Laurie Leader - Re: BP#2015-00937 38 Savoy Street - Shed permit

From: Joslin Howe <joslinhowe@gmail.com>
To: Laurie Leader <LRL@portlandmaine.gov>
Date: 8/30/2015 2:56 PM
Subject: Re: BP#2015-00937 38 Savoy Street - Shed permit
Attachments: image.jpg

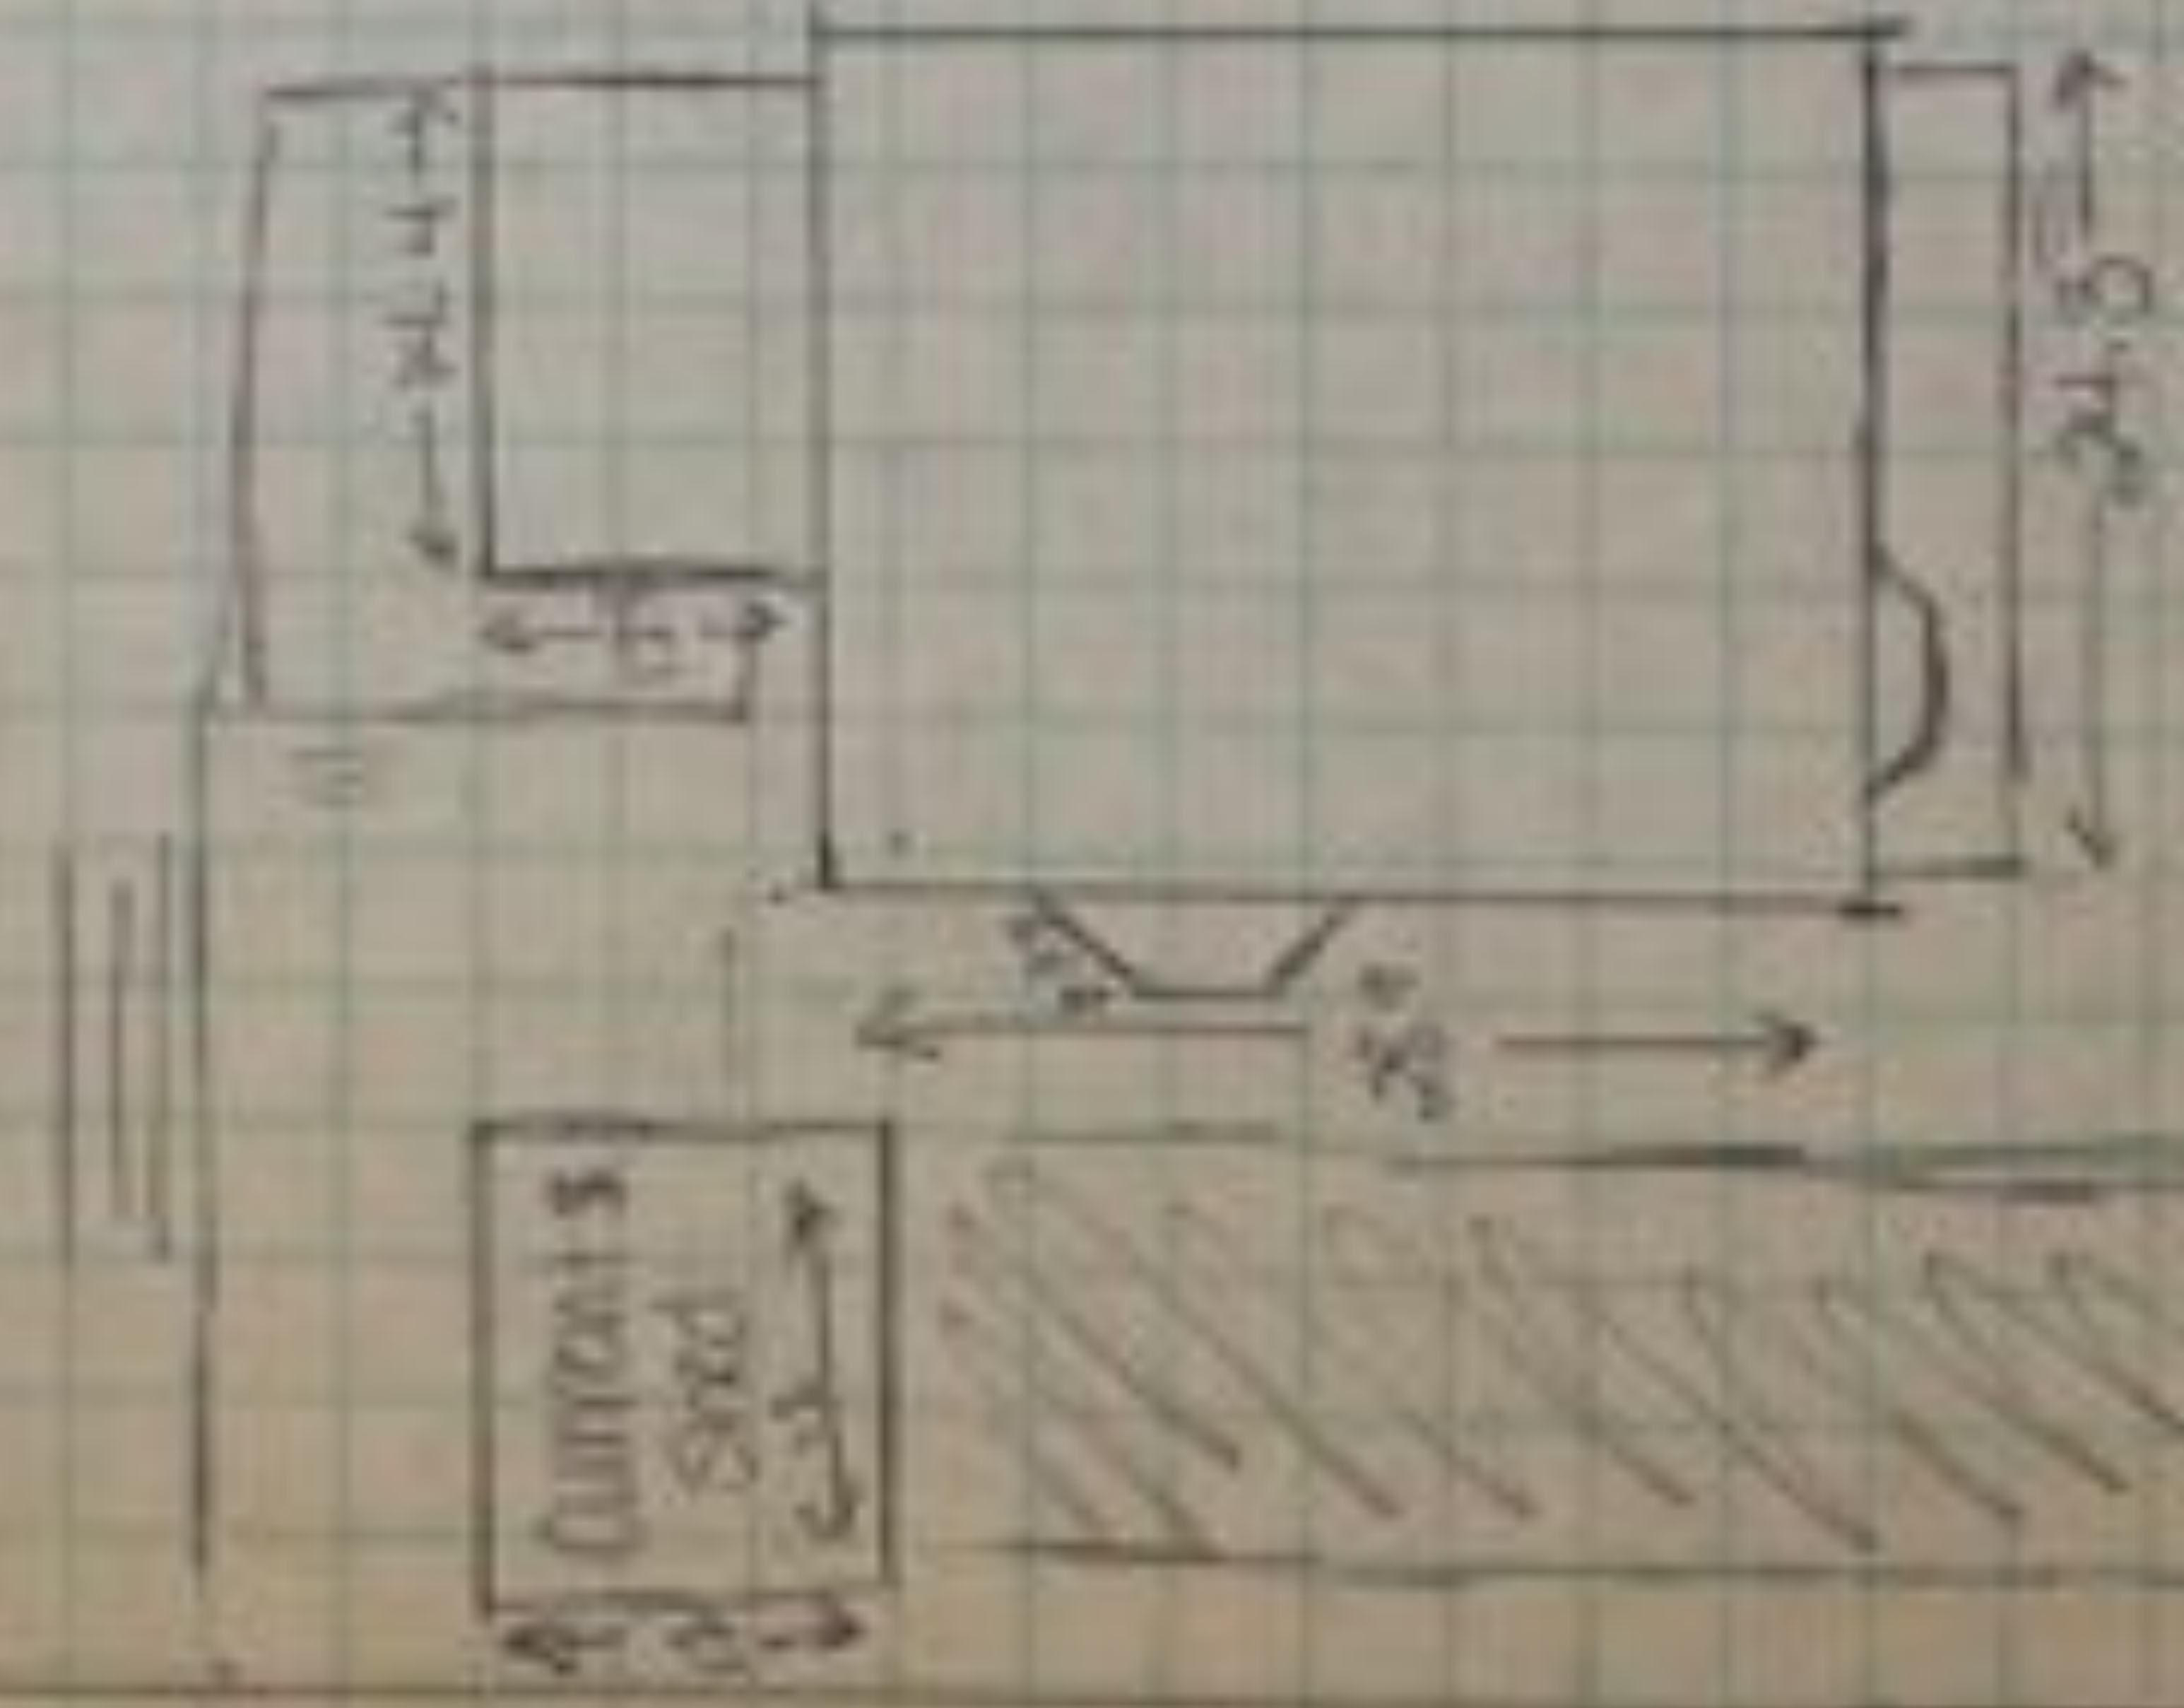
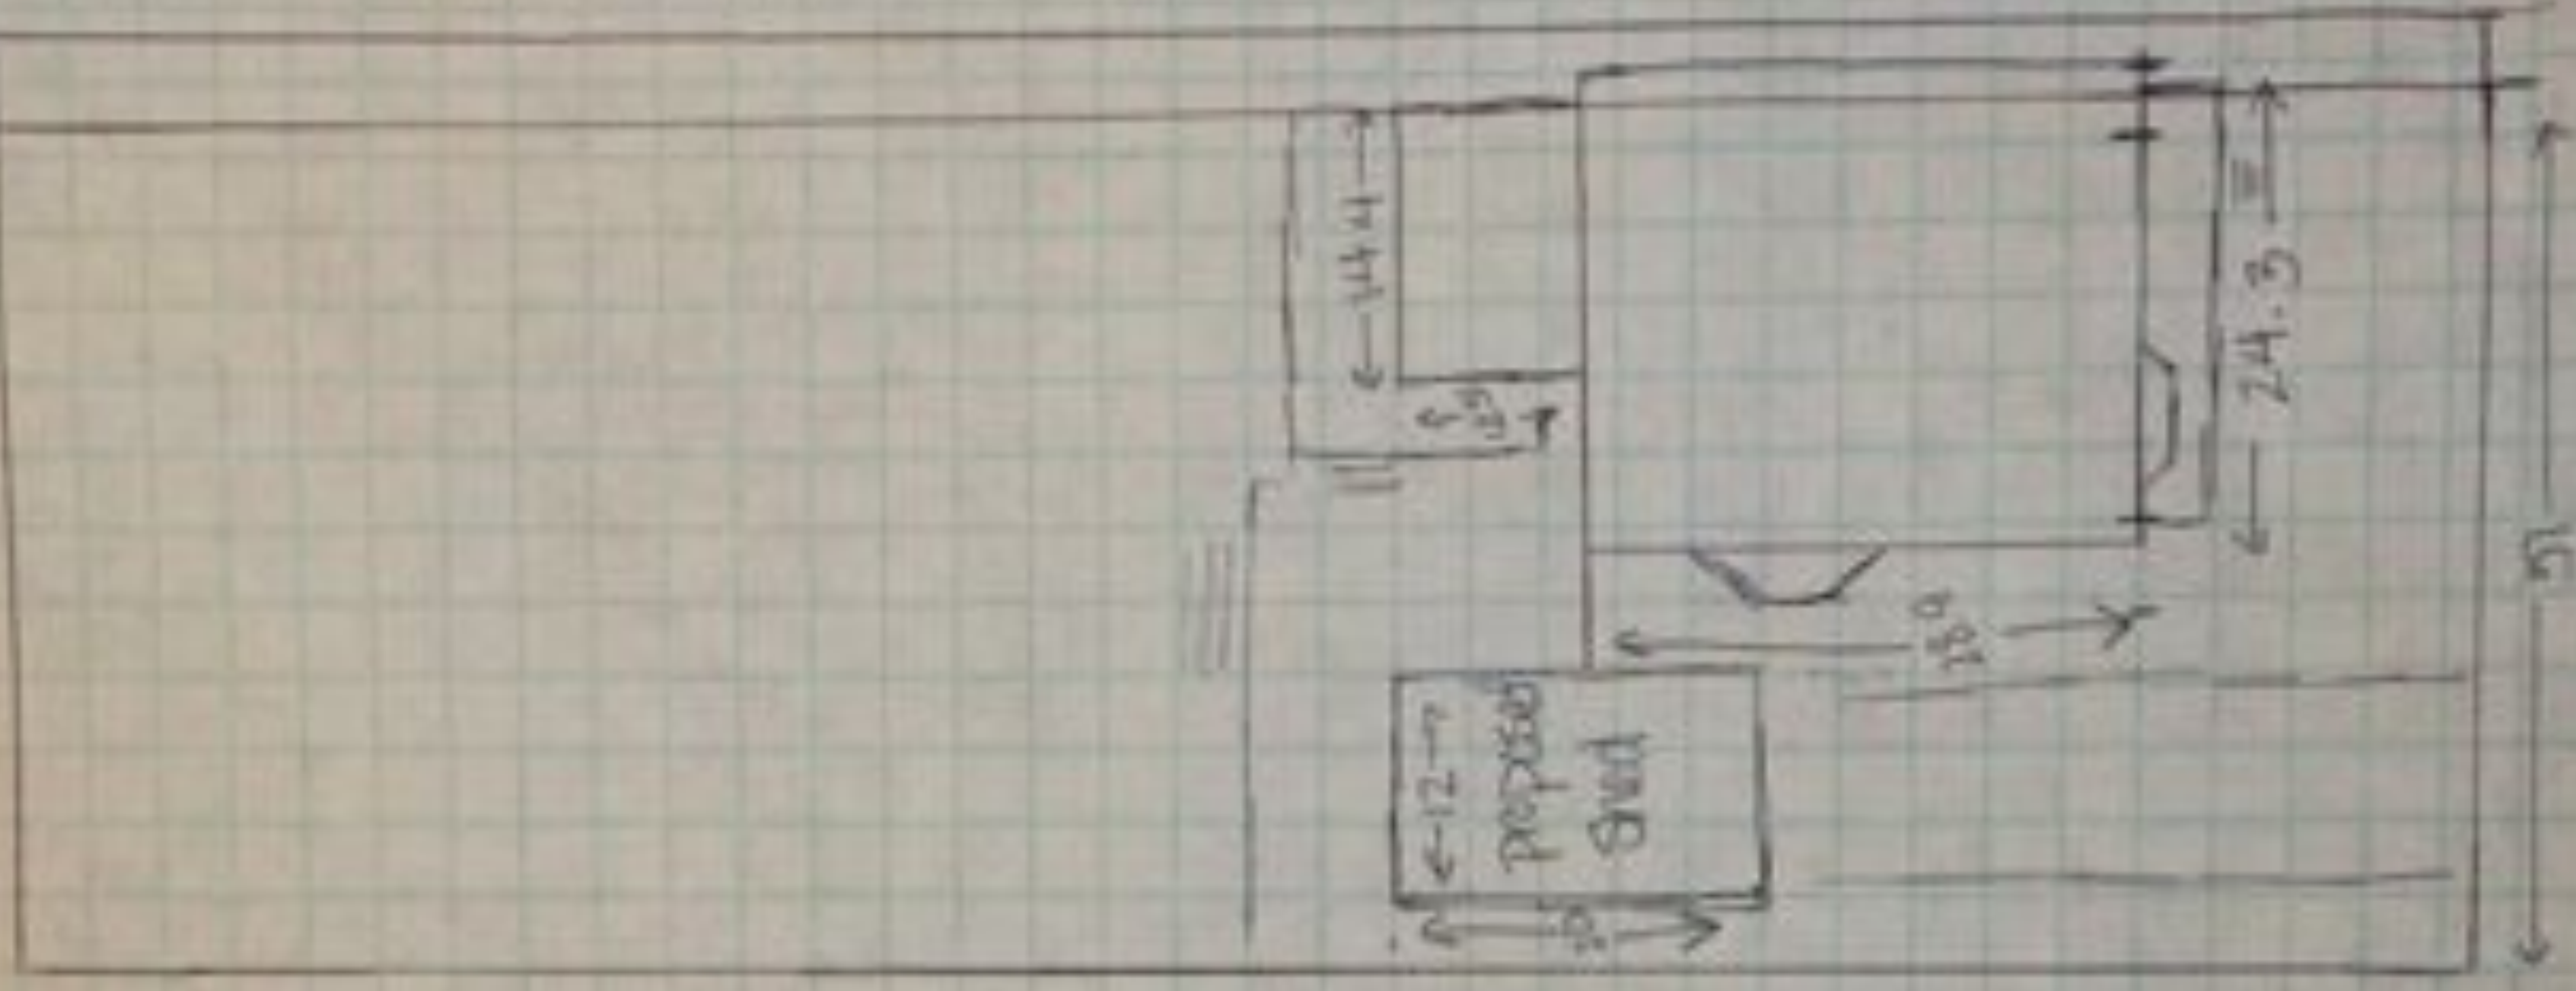
Joslin,
 Yes please resubmit showing foot setback.
 Thanks,
 Laurie

I've measured a section of the fence closer to the house, which is 3 feet. I am able to remove that portion and move the shed over the 3 feet. Do I need to resubmit another sketch?

Joslin,
 Yes we need to me the 5 foot setback requirement.
 Thanks,
 Laurie

If I were to move the shed over three feet (which would meet the 5 foot set back), would it be approved?

Here is the new sketch including the five foot setback.
